Please find amended plans showing a reduced car barn as discussed during our telephone conversation this morning.

Amended drawings from my point of view (waiting for Martyn's comments)
However, the proposed Car Barn has rather prominent position and it is too dominant and even larger (southern elevation) than the barn 3 itself. It should be amended; simple structure to serve the use.

Please find amended plans addressing the concerns raised in our numerous correspondence. The key amendments are as follows:

Drawing Title
Proposed Plans - Barn 2

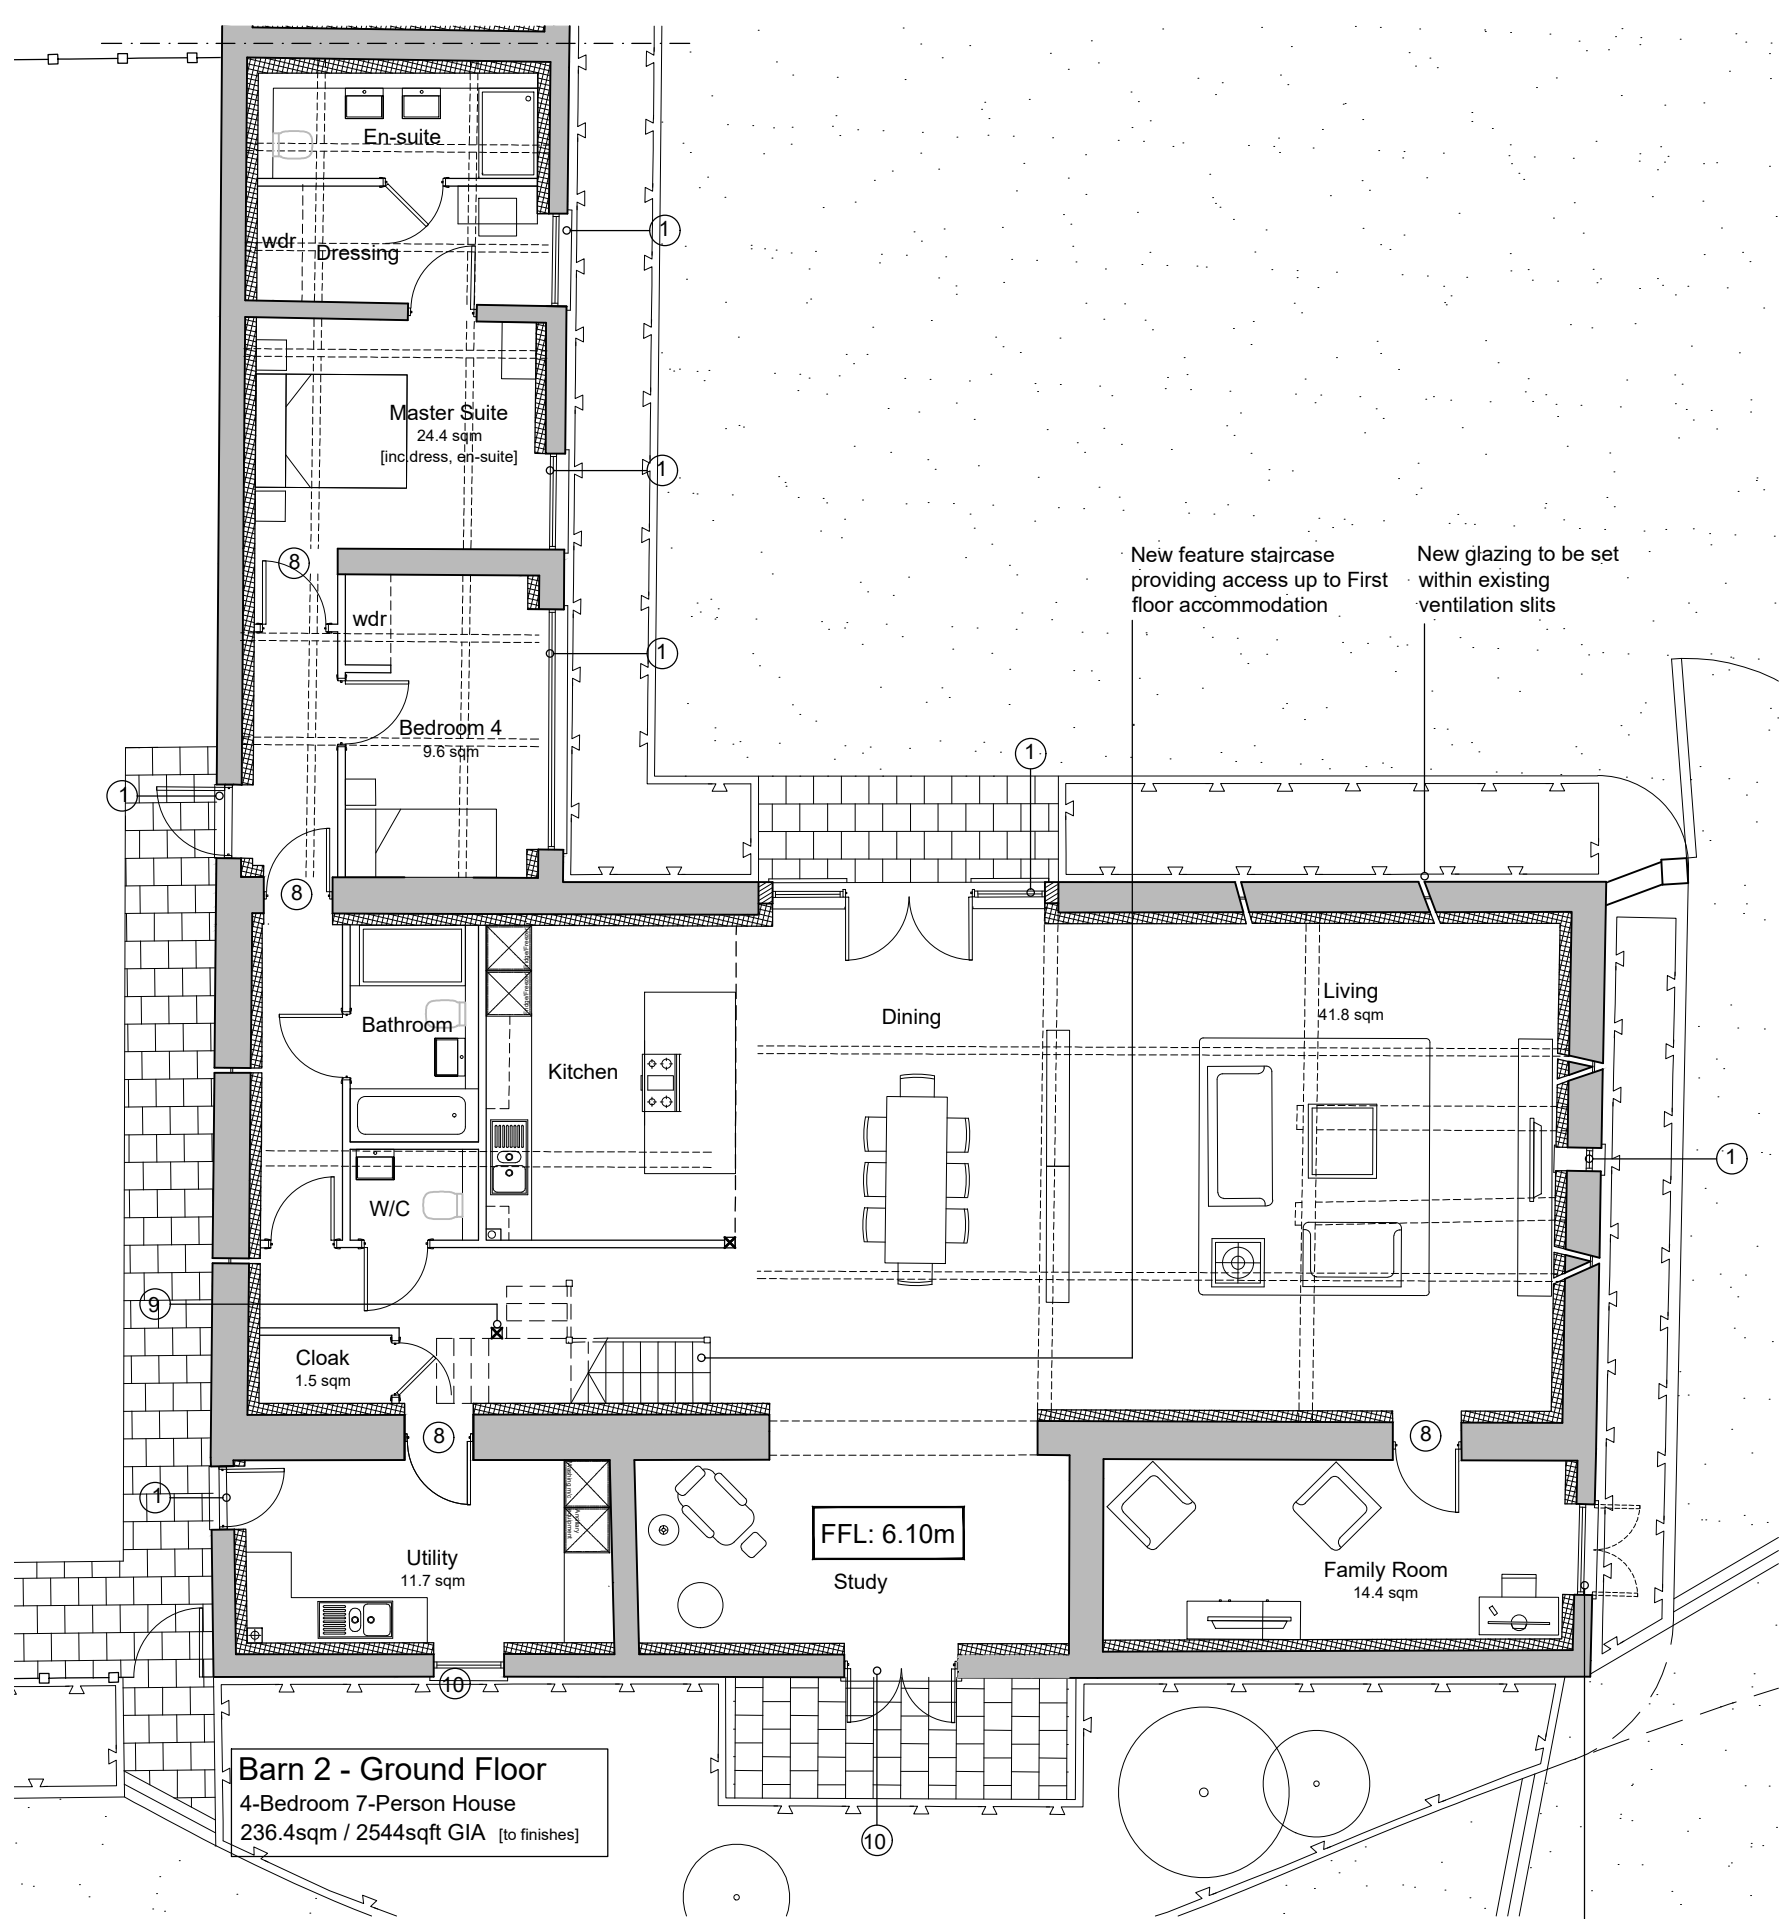
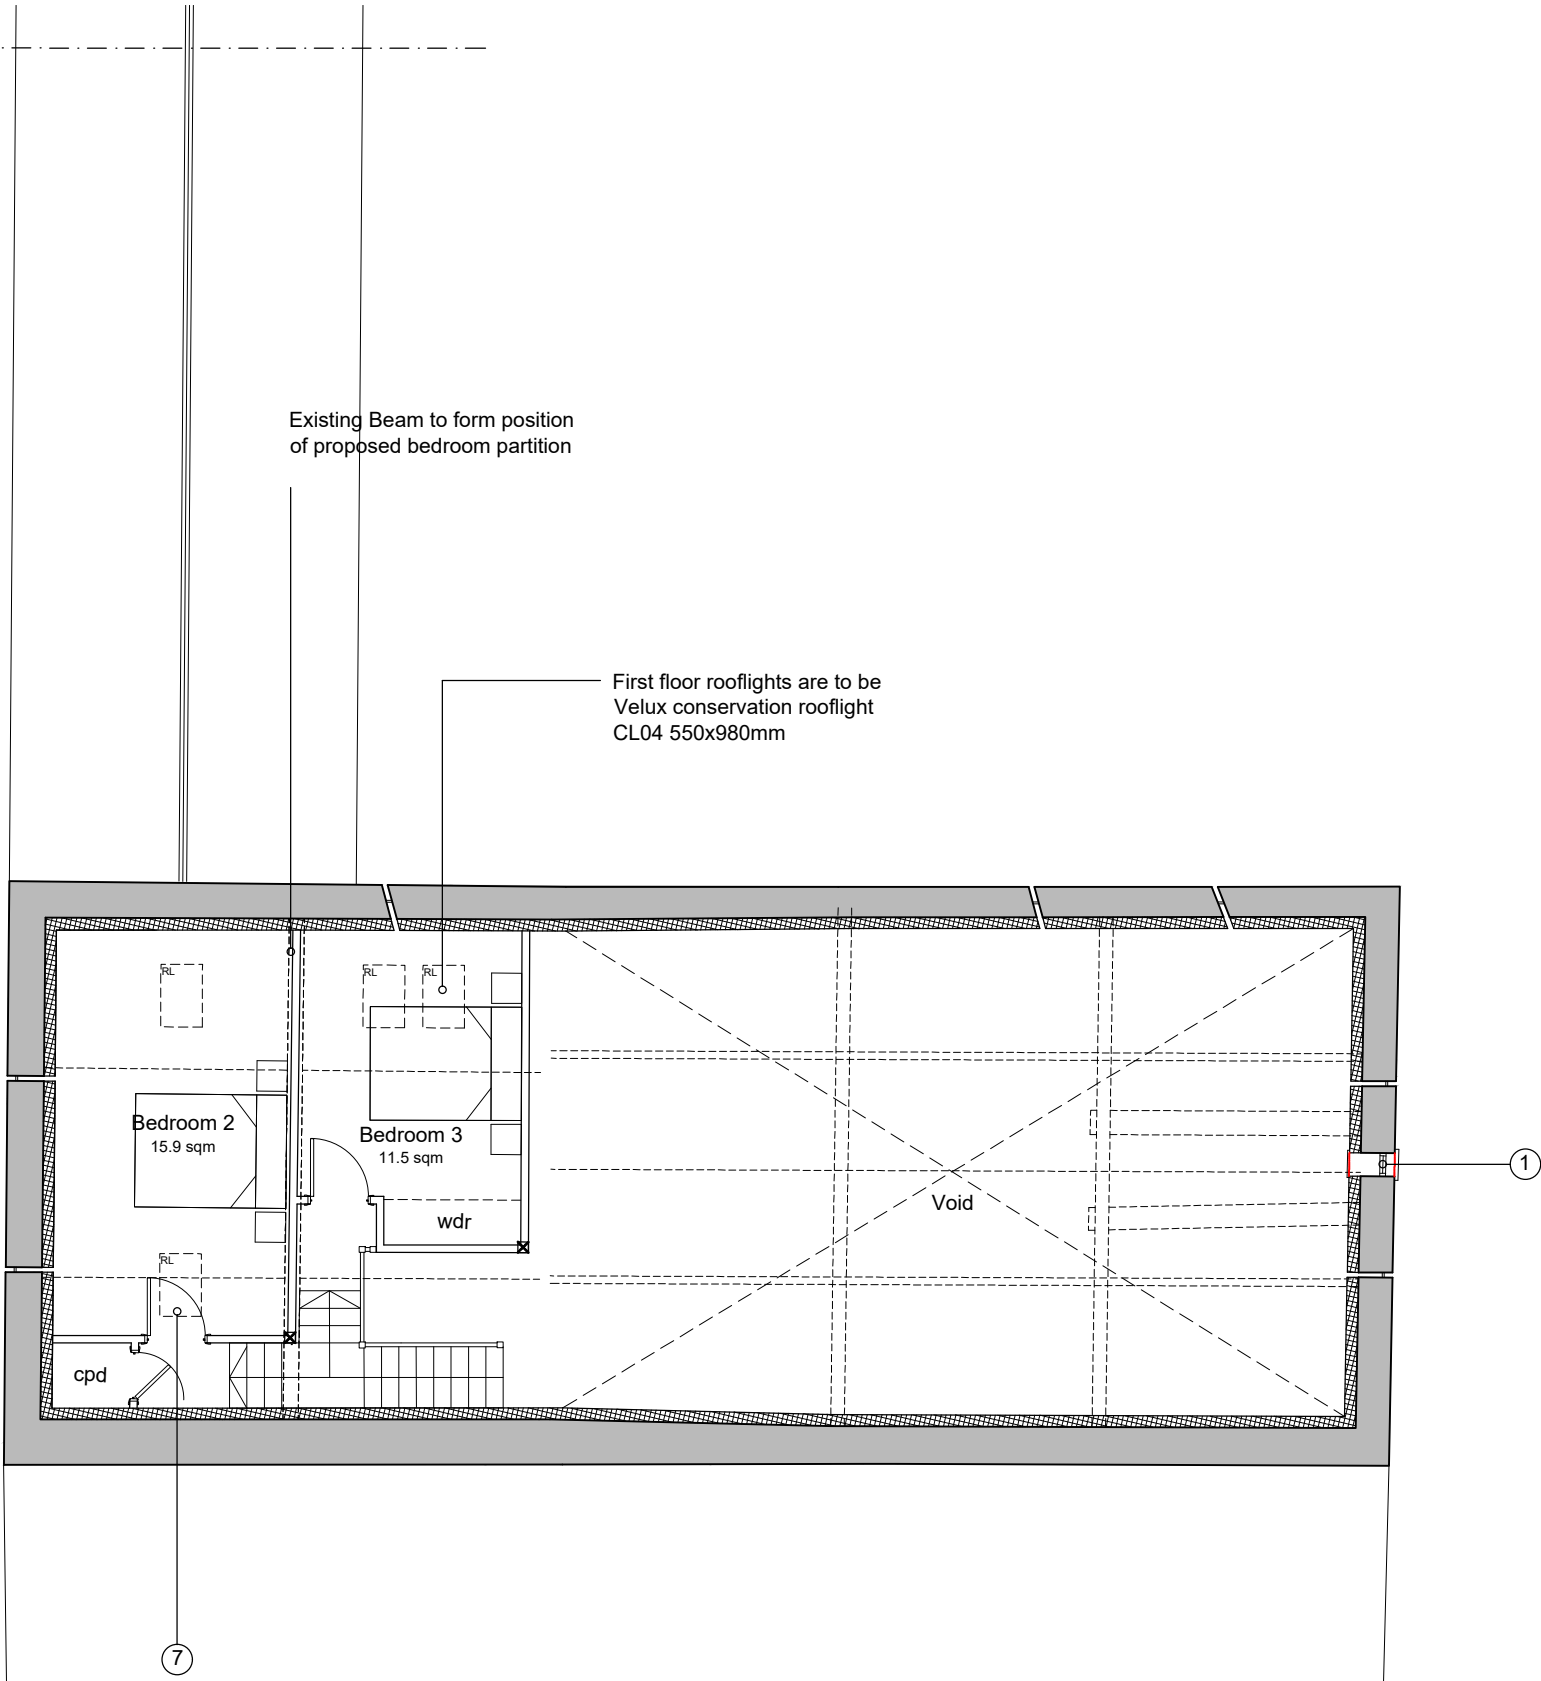
- Windows on east elevation of single storey element reflect the existing openings as closely as possible.
- South elevation – the size/number of doors on the south elevation have been reduced in size to reduce the impact as far as possible whilst allowing access to the courtyard.
- North elevation – the number of rooflights has been reduced as per our telephone conversation in early April.
